RE: 965 Forest Avenue – 142-B-001 – B-2 Zone -permit application #04-0301

I am in receipt of your permit application to change the use from a print shop to a pub and restaurant. Your permit can not be issued without further information.

C.J.'s Place  
 Pub + Restaurant  
 963-967 Forest Ave  
 Portland, Me. 04103

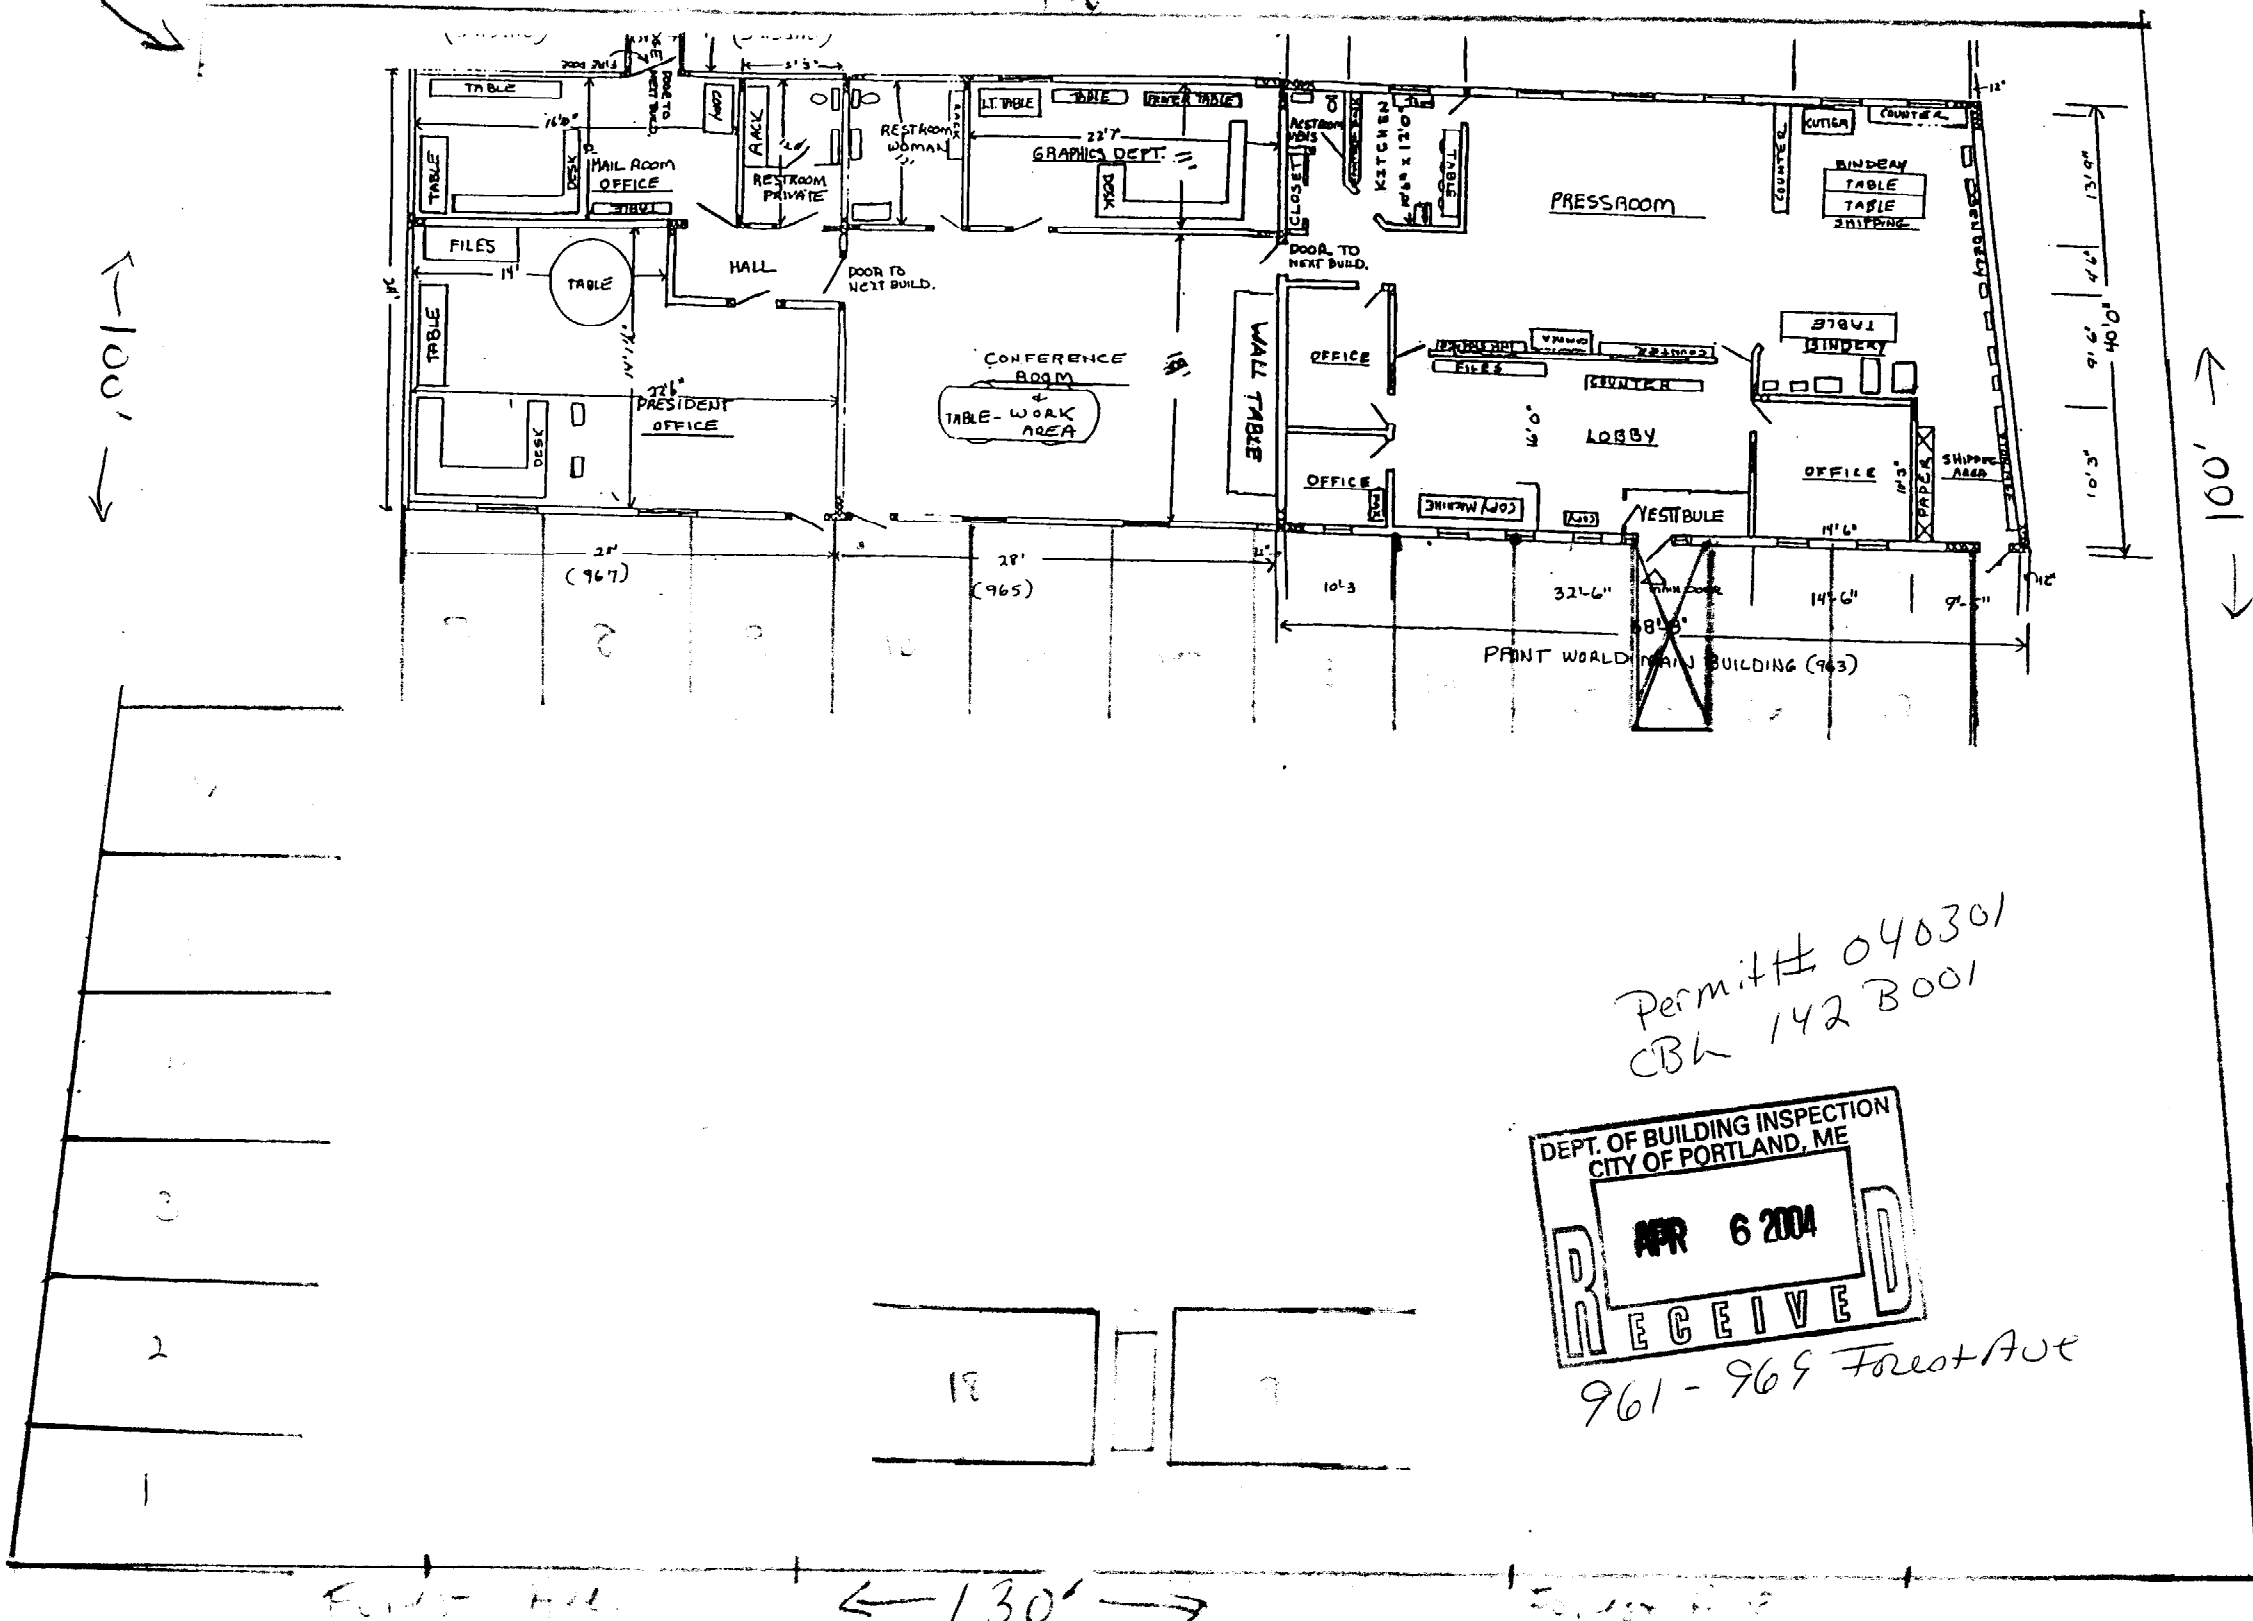
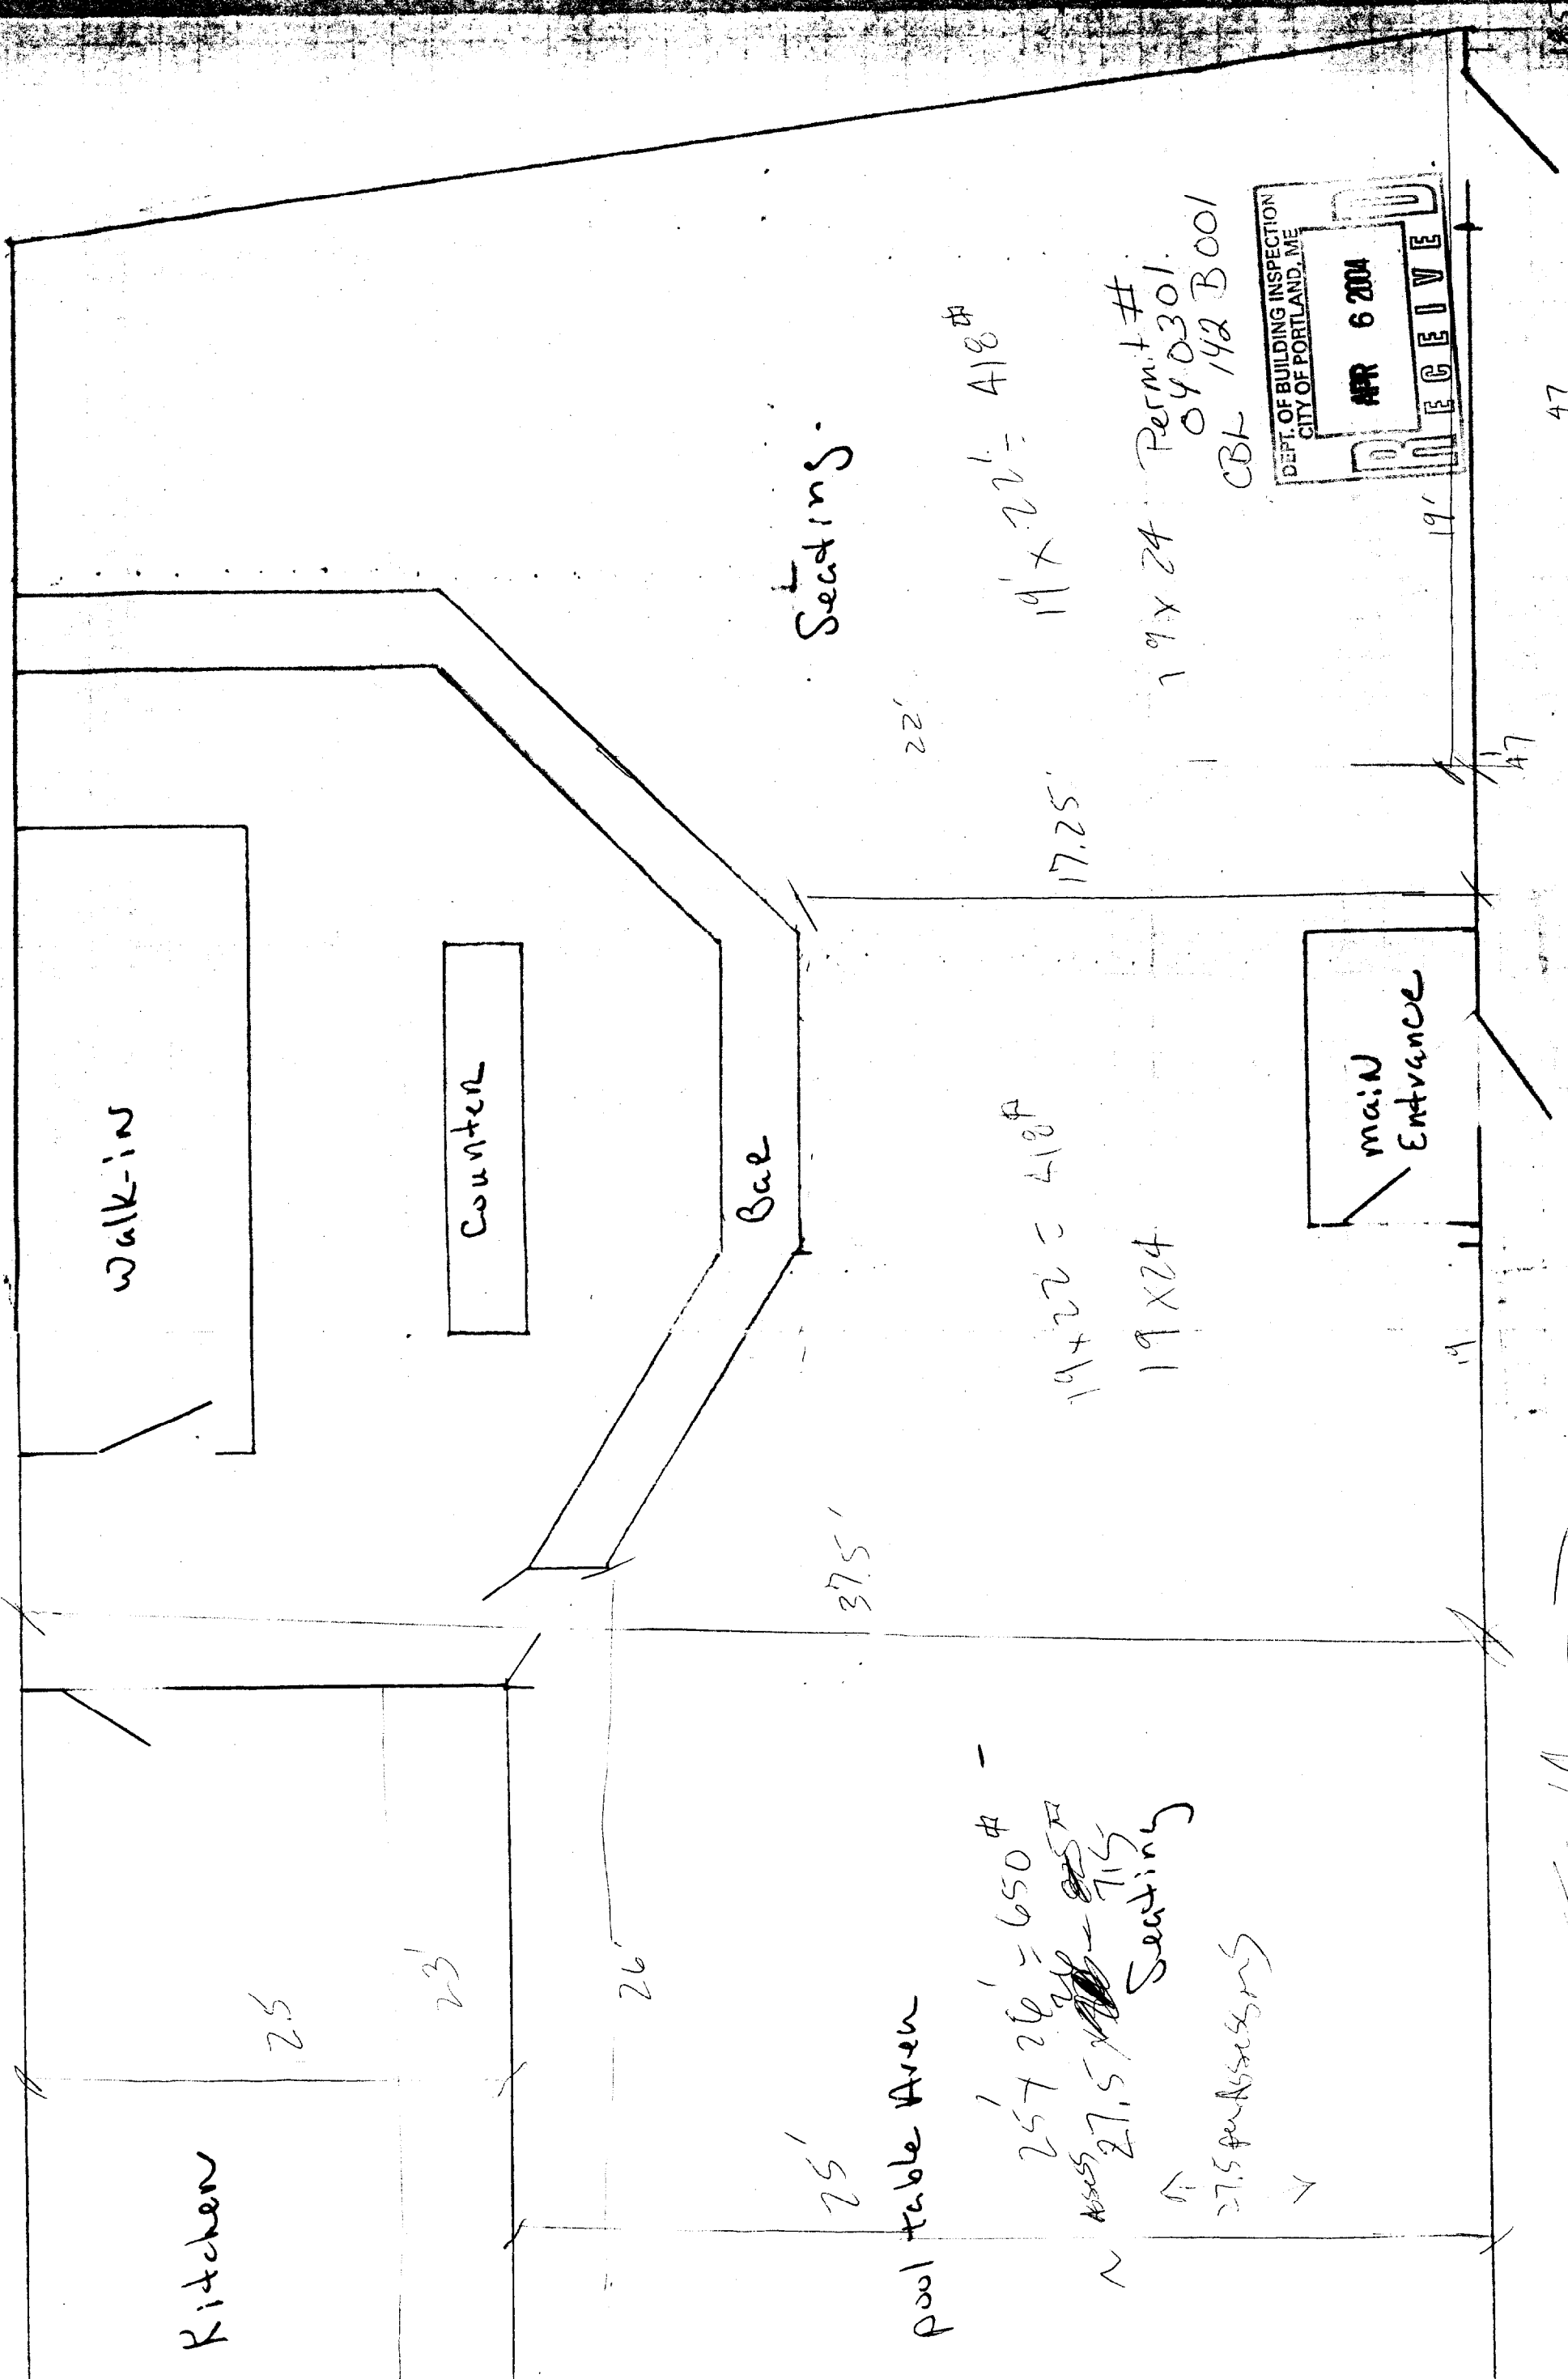
First, your submitted plans are not drawn to scale. It will be necessary to submit floor plans that are accurately scaled with all dimensions. Second, it is also required to submit a plot plan showing all available off-street parking for this change of use. All parking spaces shall be drawn on this plan. In order to determine parking requirements for this building (your use and any other uses within this property), it will be necessary to know the sizes of all existing spaces and their uses.
